Technical Note

Project No: ITB13091
Project Title: Ford Airfield – The Landings
Title: Sustainable Accessibility Addendum Note
Ref: 13091-029
Date: 5 August 2020

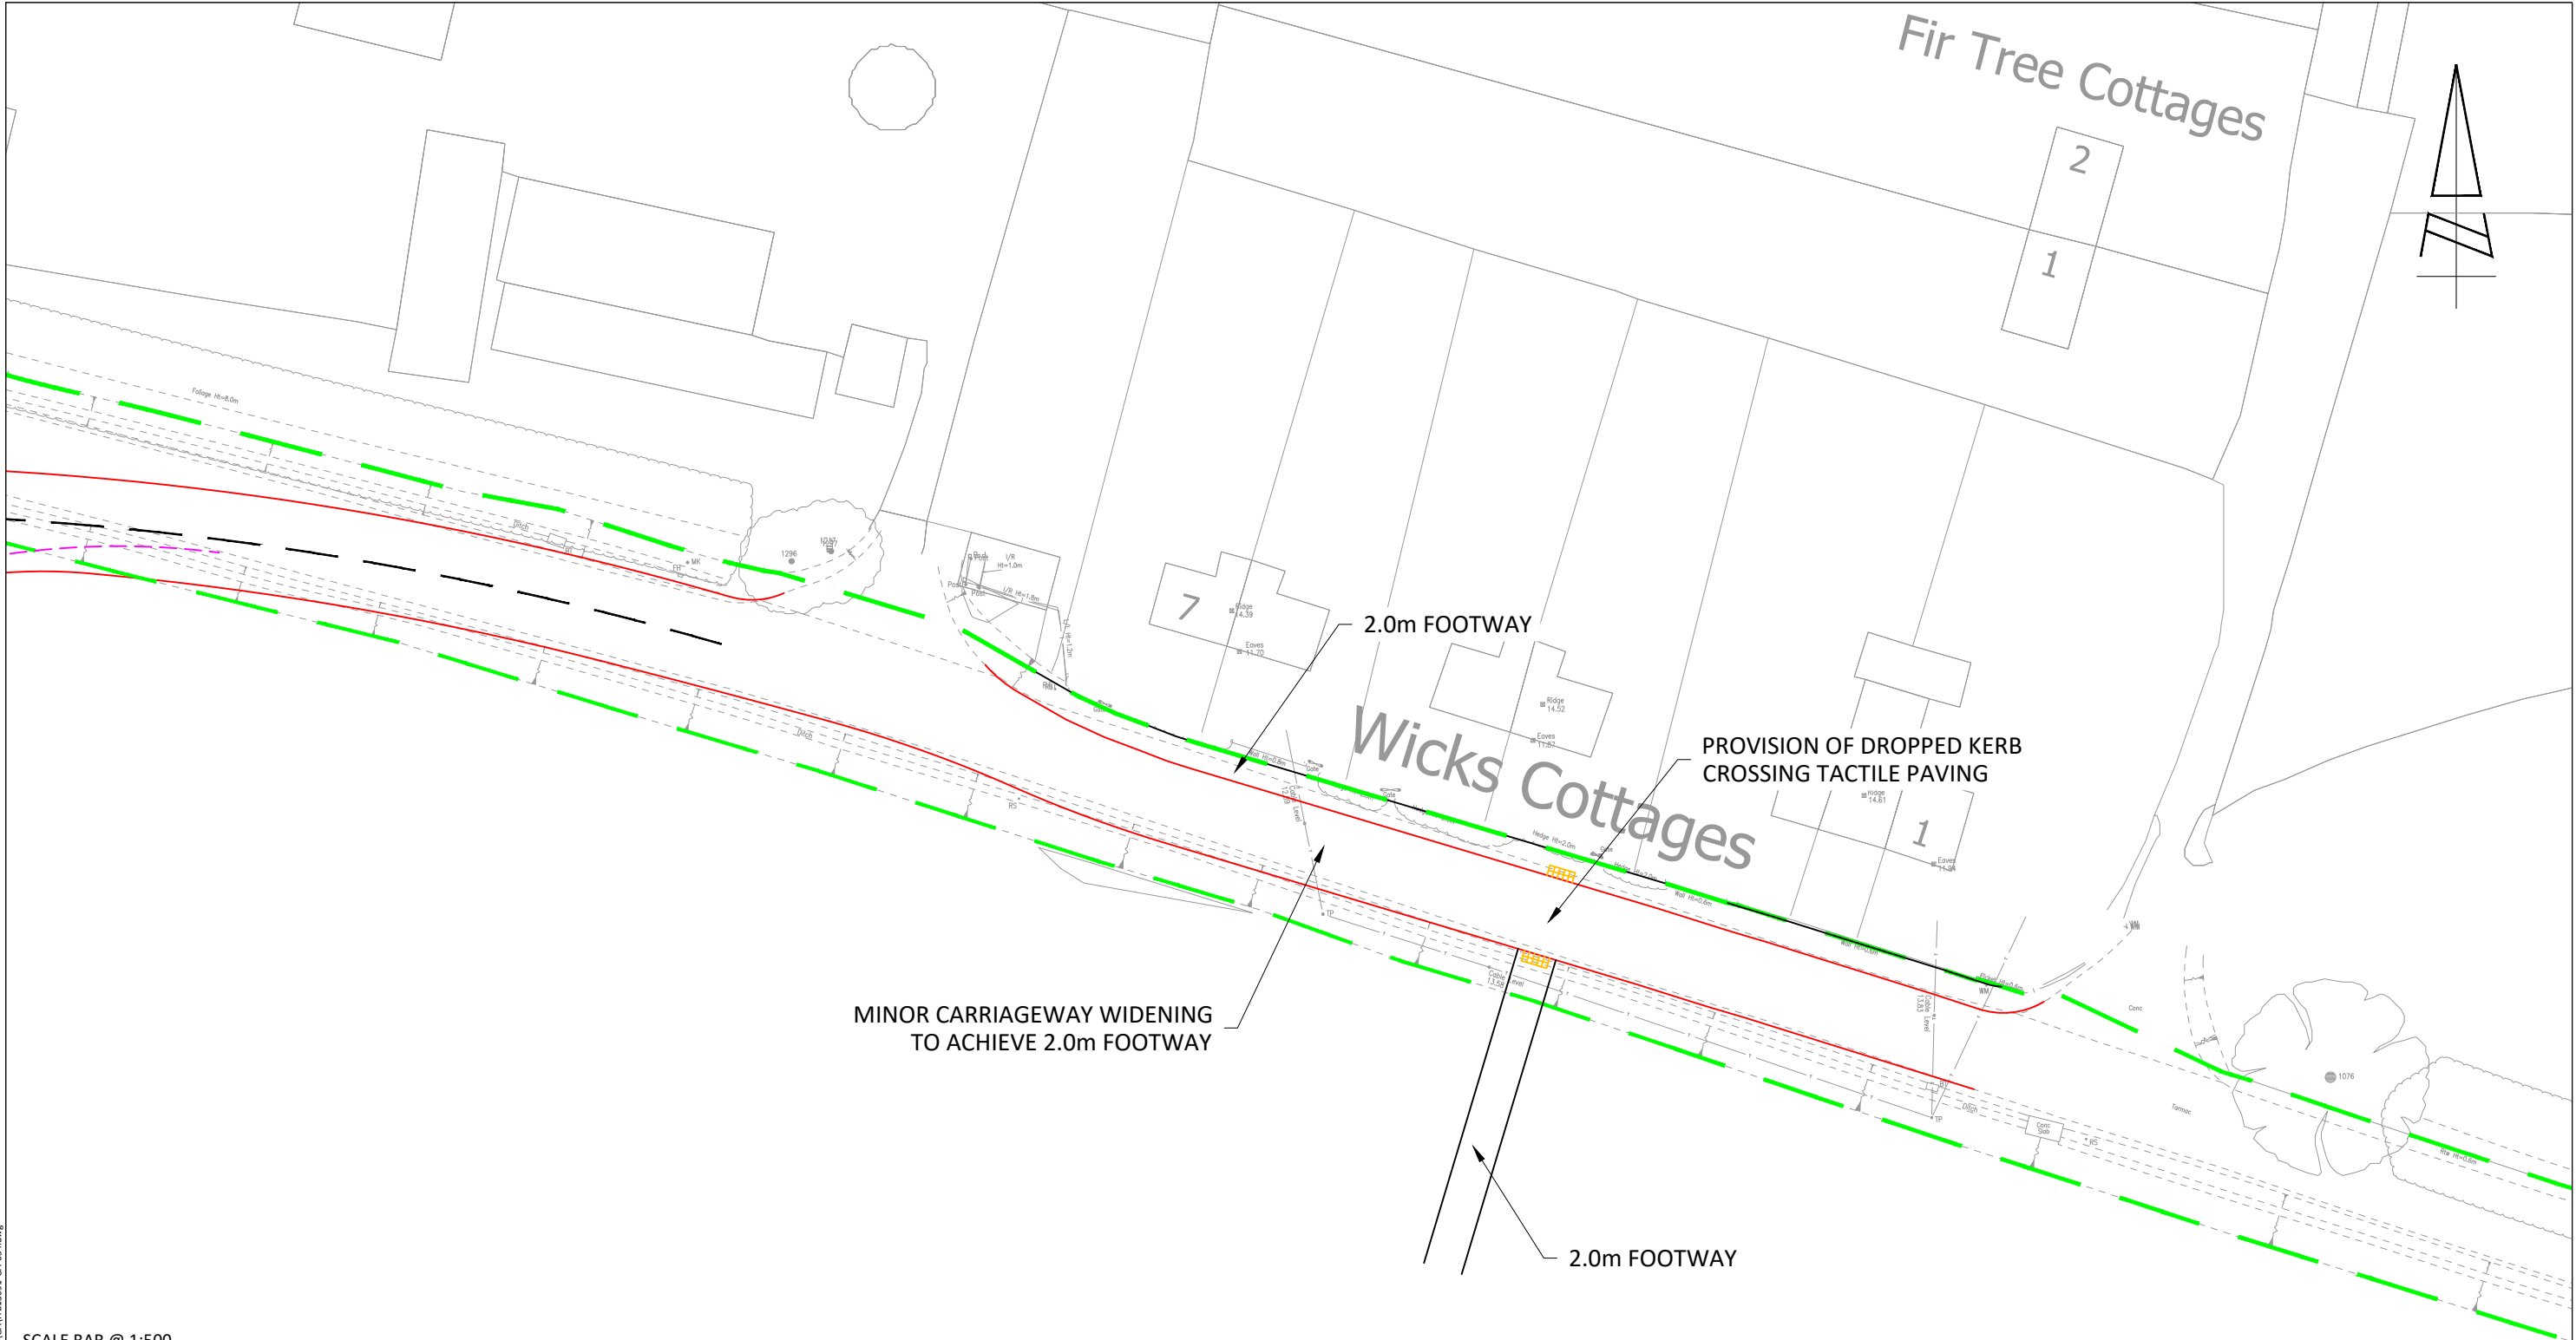
3.4.1 WSCC has requested that further consideration be given to the existing pedestrian infrastructure along Horsemere Green Lane and identify any further improvements that may be required.

- 3.4.2 There is sporadic pedestrian provision along Horsemere Green Lane, with a continuous footway commencing in the vicinity of May Close in an eastbound direction. **Drawing ITB13091-GA-058** proposes a scheme of footway improvements to complete the missing links in the provision.

- 3.4.3 The proposed improvements will extend the footway along the entirety of Horsemere Green Lane, culminating with a dropped kerb and tactile paving crossing of Yapton Road to provide access to the existing northbound bus stop on Yapton Road. The footway continues in an eastbound direction on the northern side of Horsemere Green Lane, along the southern boundary of the development, before crossing to the southern side of the carriageway to continue and connect with the existing provision at the Horsemere Green Lane/May Close junction. Dropped kerb and tactile paving crossings are proposed at all junctions to assist crossing manoeuvres.
